Subject: Fw: AMENDED SITE PLAN -THE STABLES MAIN STREET GREAT BOURTON 22/00499/DISC

Subject: AMENDED SITE PLAN -THE STABLES MAIN STREET GREAT BOURTON 22/00499/DISC

I am writing to make objections to the amended site plan for the above application and also other important issues that still do not seem to have been dealt with.

# SITE LAYOUT PLAN

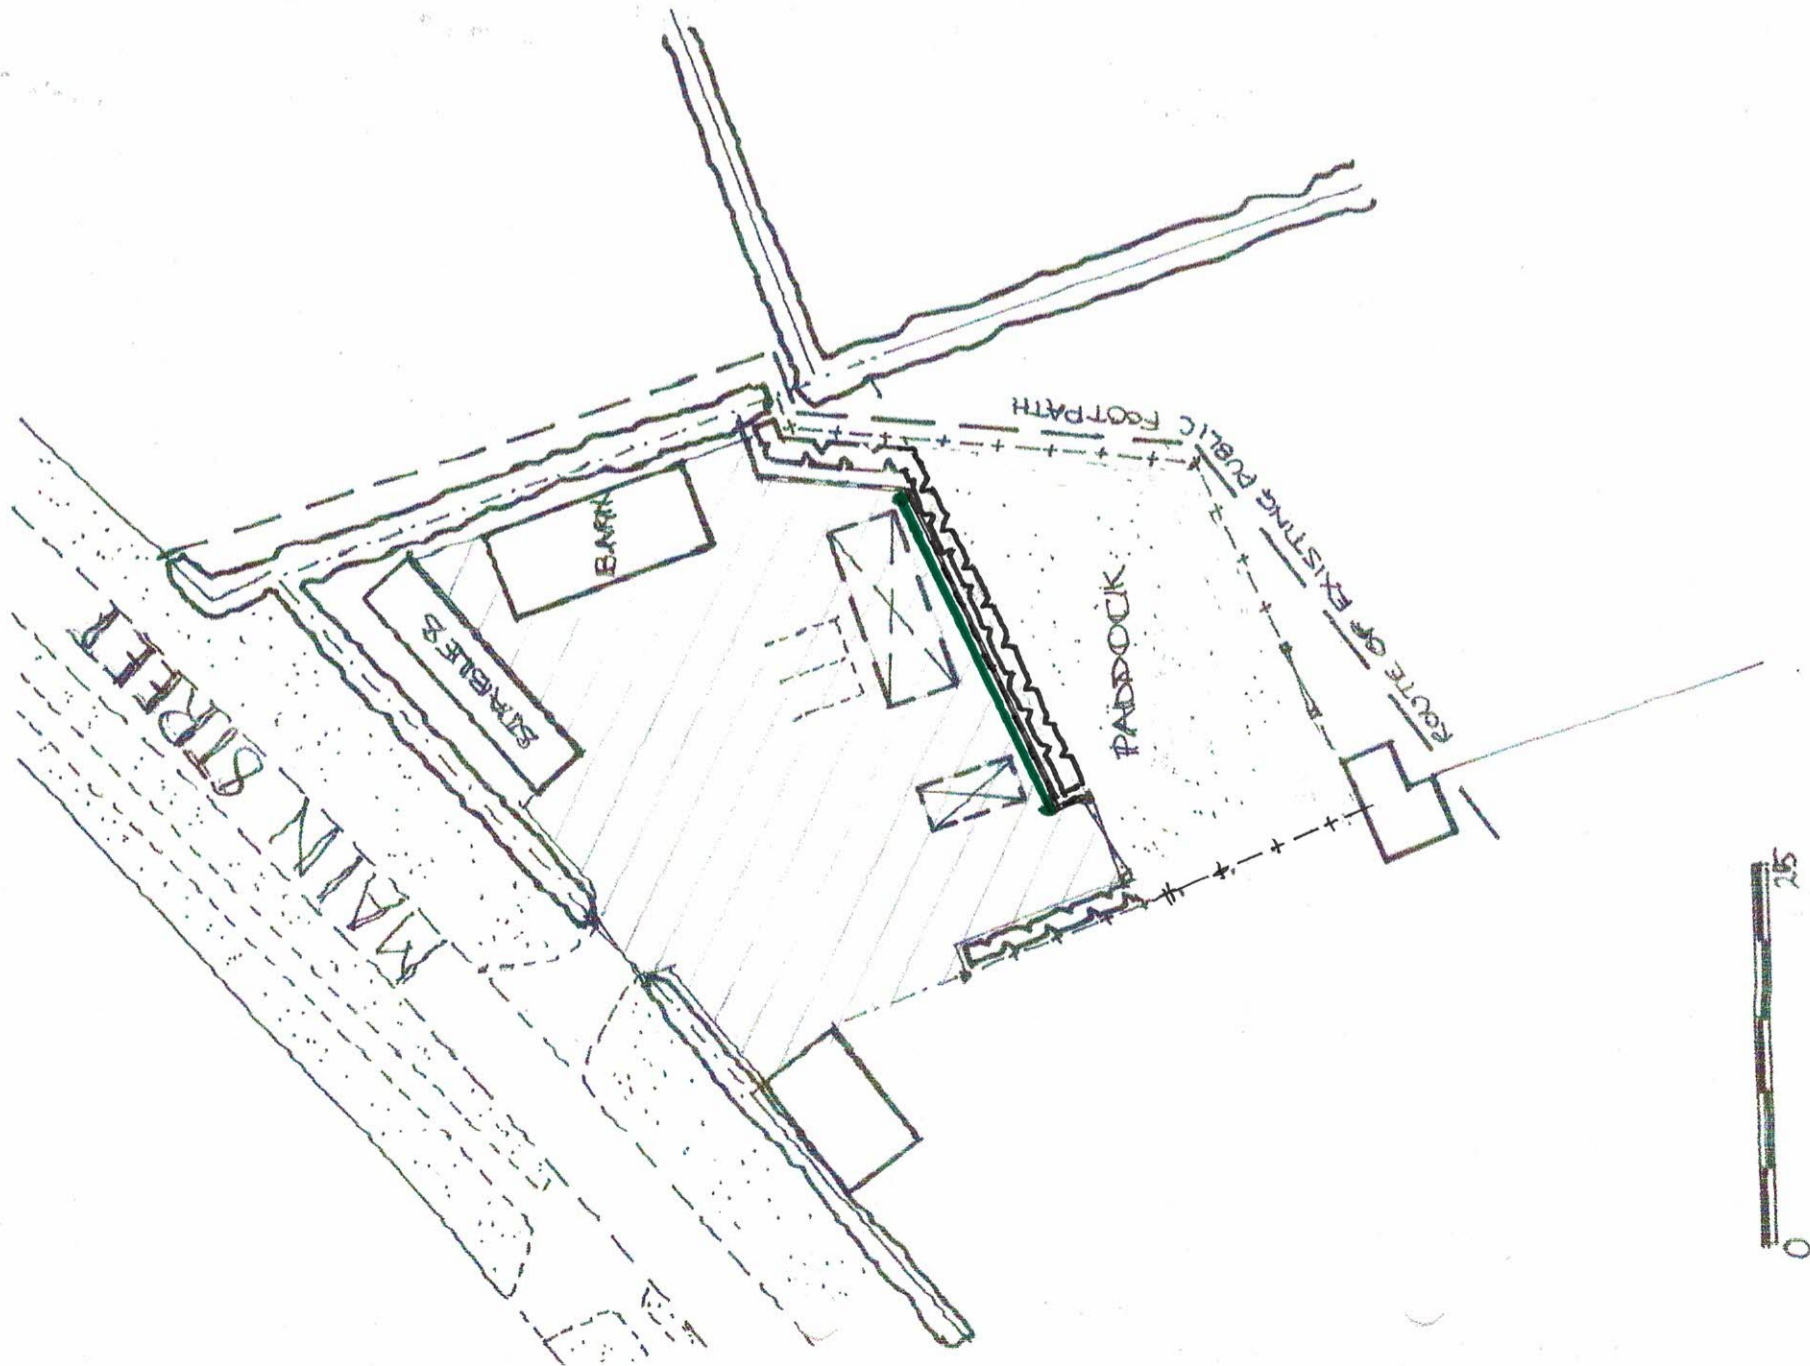
The new site plan is again showing the line of the public footpath that crosses the site as incorrect. It shows the line of the path as going around the site on a permissive route that the owner himself created and not through the site on the legal route! Indeed Beth Rutterford O.C.C has objected to the latest plan and also questions the incorrect line of the path, the proposed screen fence/planting that

may obstruct the definitive line of the footpath and would need to be adjusted as suggested on her plan to resolve the issue. She also says that the adjusted fence would then hopefully separate any dogs on the site from footpath users. At this point I must comment that there have been problems with dogs on this site for some time with members of the public threatened and even bitten and in recent weeks there have been two more incidents where a walker's dog was attacked and another walker received a nasty bite! This is not acceptable and the least CDC should do is seriously consider the advice from Beth Rutterford regarding the footpath and site boundary and ensure any fence/planting is erected so that it leaves the legal footpath securely outside of the caravan site area.
